February 18, 2020

RE: **6429 Dennison SW**
Request for Pad Certification – Approved
Grading Plan Stamp Date: 9/18/19
Certification Dated: 2/5/20
Drainage File: K11D068A

<p>ENGINEER'S SEAL</p>	<p>LOT 8 BLK B ALAMOSA ADDITION 6429 DENNISON ROAD</p>	<p>DRAWN BY DEM</p>
	<p>GRADING AND DRAINAGE PLAN</p>	<p>DATE 9-16-19</p>
<p>9/18/19</p>		<p><i>Rio Grande Engineering</i></p>
<p>DAVID SOULE P.E. #14522</p>	<p>1606 CENTRAL AVENUE SE SUITE 201 ALBUQUERQUE, NM 87106 (505) 872-0899</p>	<p>SHEET # C1</p>
		<p>JOB #</p>

ENGINEER'S SEAL 9/18/19 DAVID SOULE P.E. #14522	LOT 8 BLK B ALAMOSA ADDITION 6429 DENNISON ROAD GRADING AND DRAINAGE PLAN 1608 CENTRAL AVENUE SE SUITE 201 ALBUQUERQUE, NM 87106 (505) 972-0899	DRAWN BY DEM
		DATE 9-16-19
		LOT 5 BLK 47 UN 10 RR DWG
		SHEET # C1
		JOB #

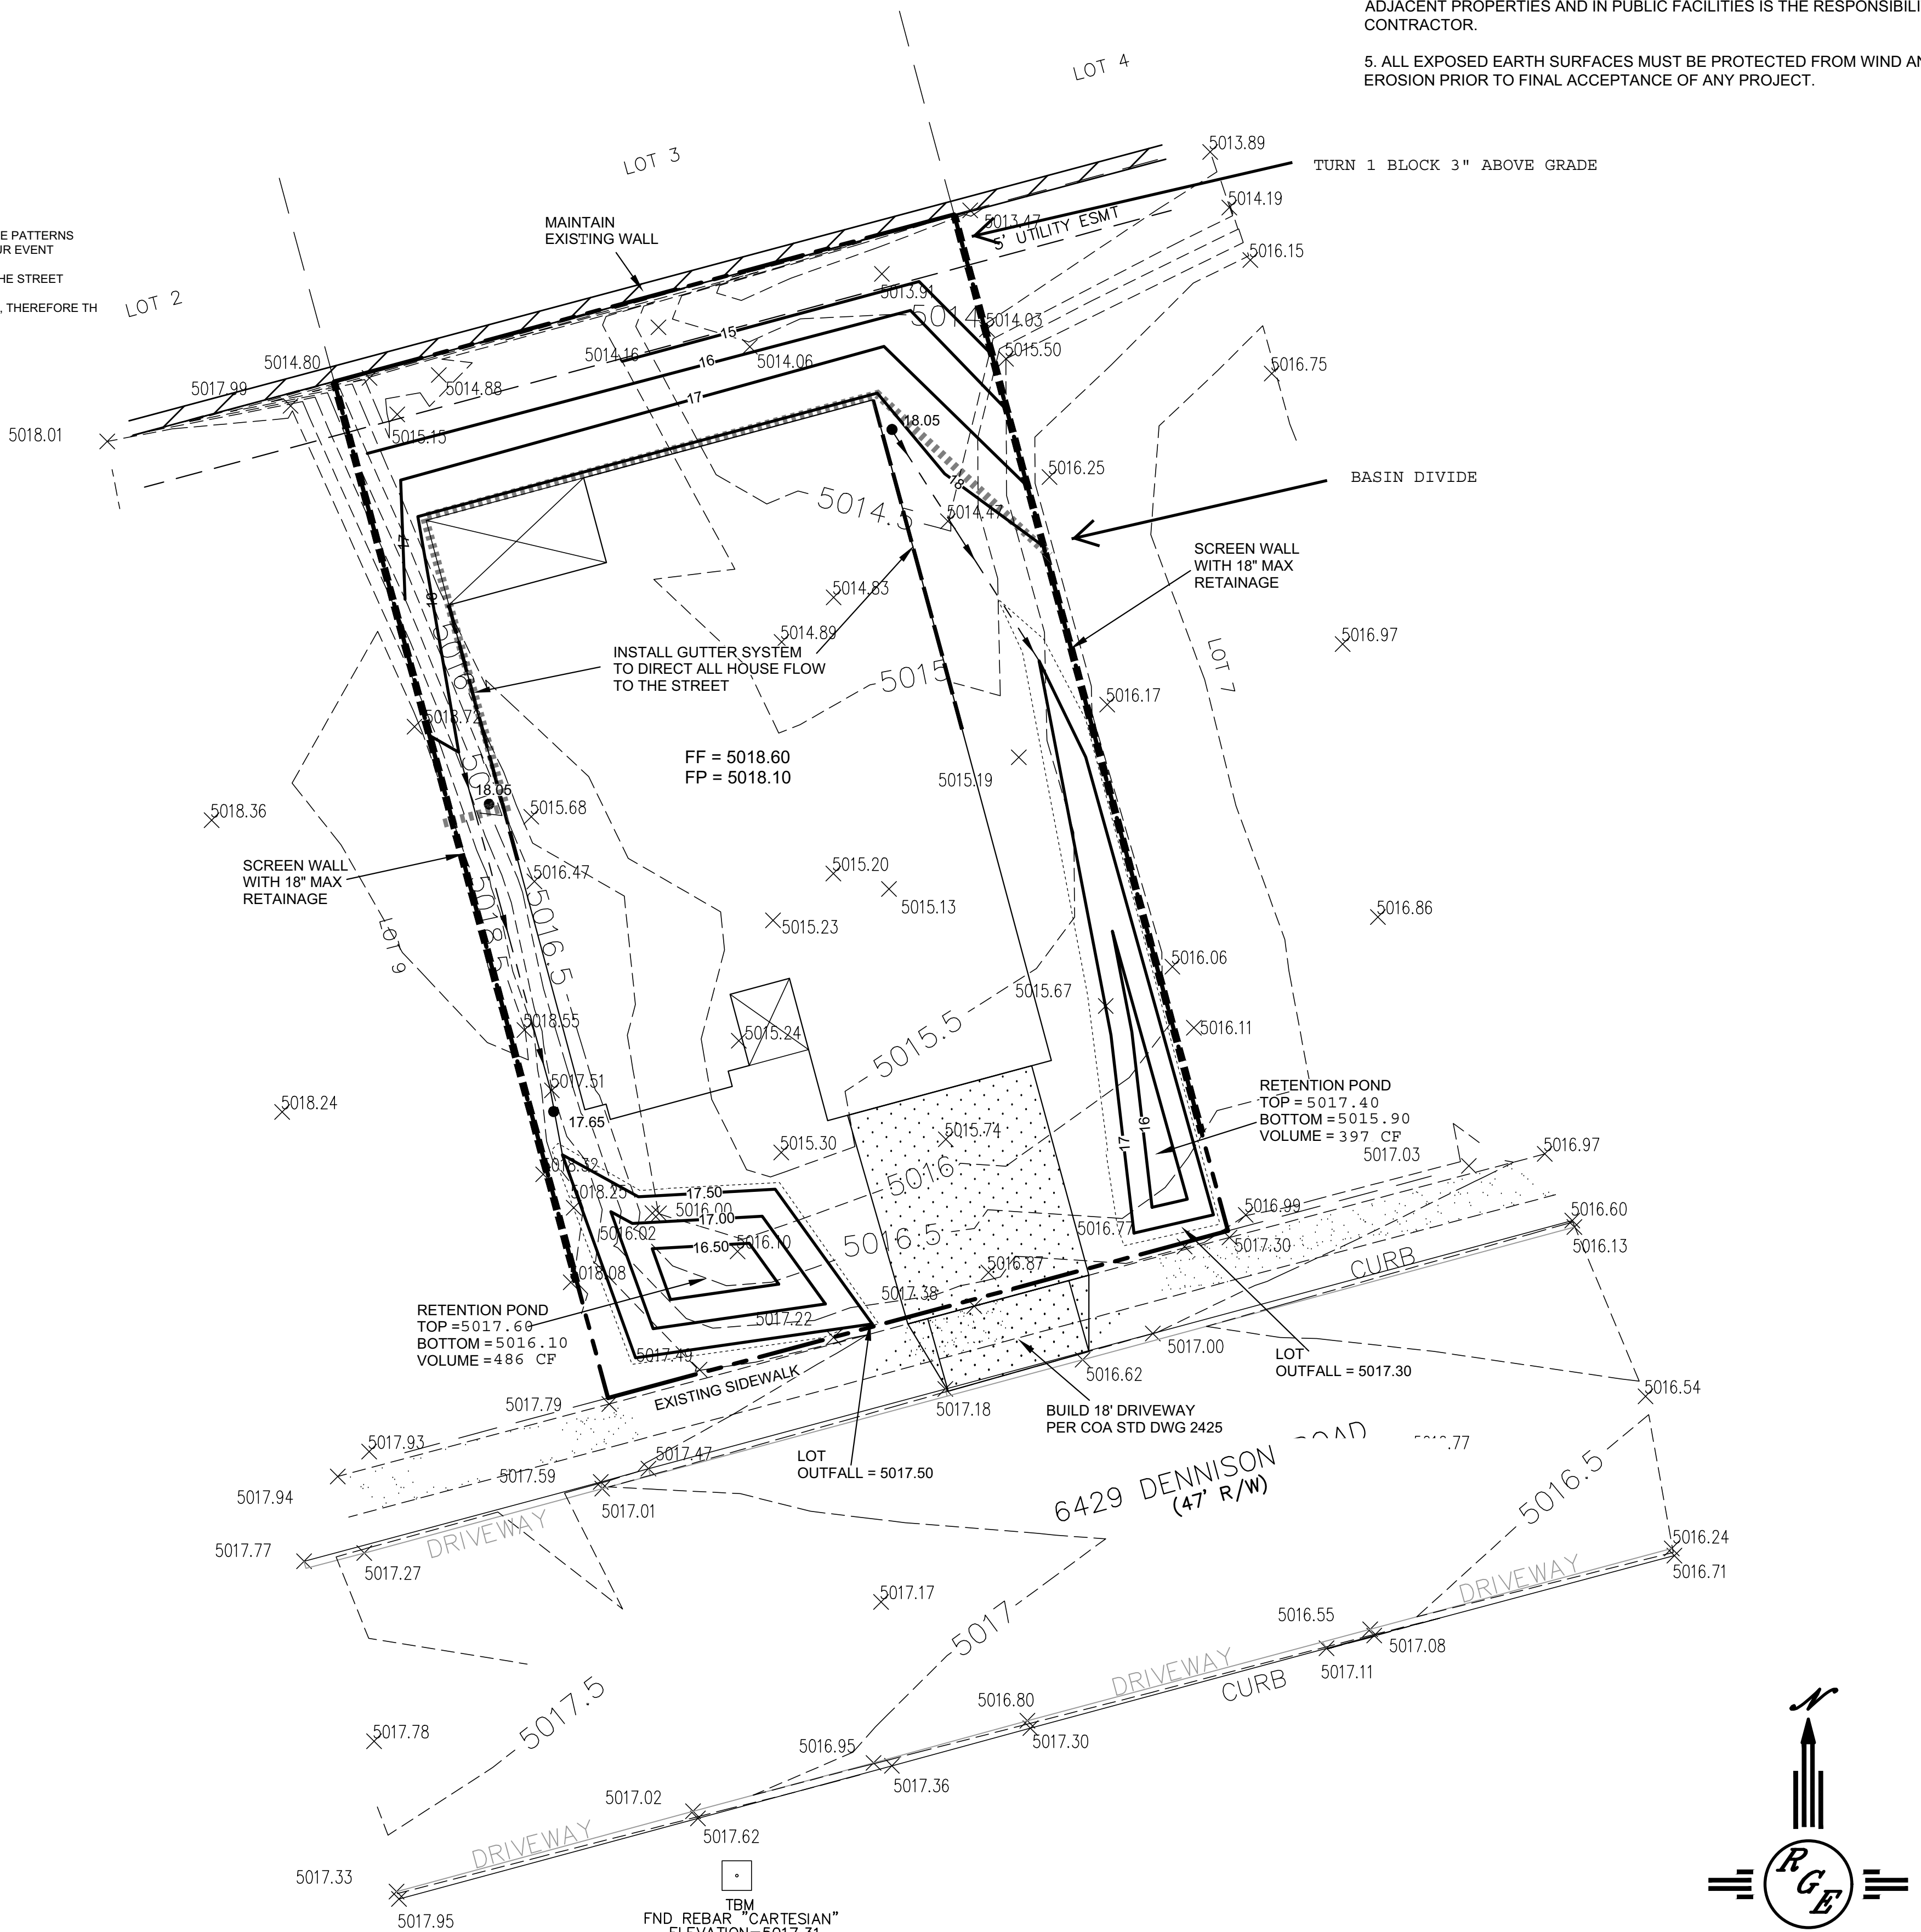
1. Provide supporting as-built survey of the compacted building pad and grades along the rear yard wall.
2. Grade the ponds according to plan and provide supporting as-built survey.
3. Use the Drainage Certification Language, per the DPM Chapter 22.7: *DRAINAGE CERTIFICATION WITH SURVEY WORK BY PROFESSIONAL SURVEYOR* or *DRAINAGE CERTIFICATION WITH VERIFICATION BY ENGINEER OF RECORD*; be sure to include surveyor information.
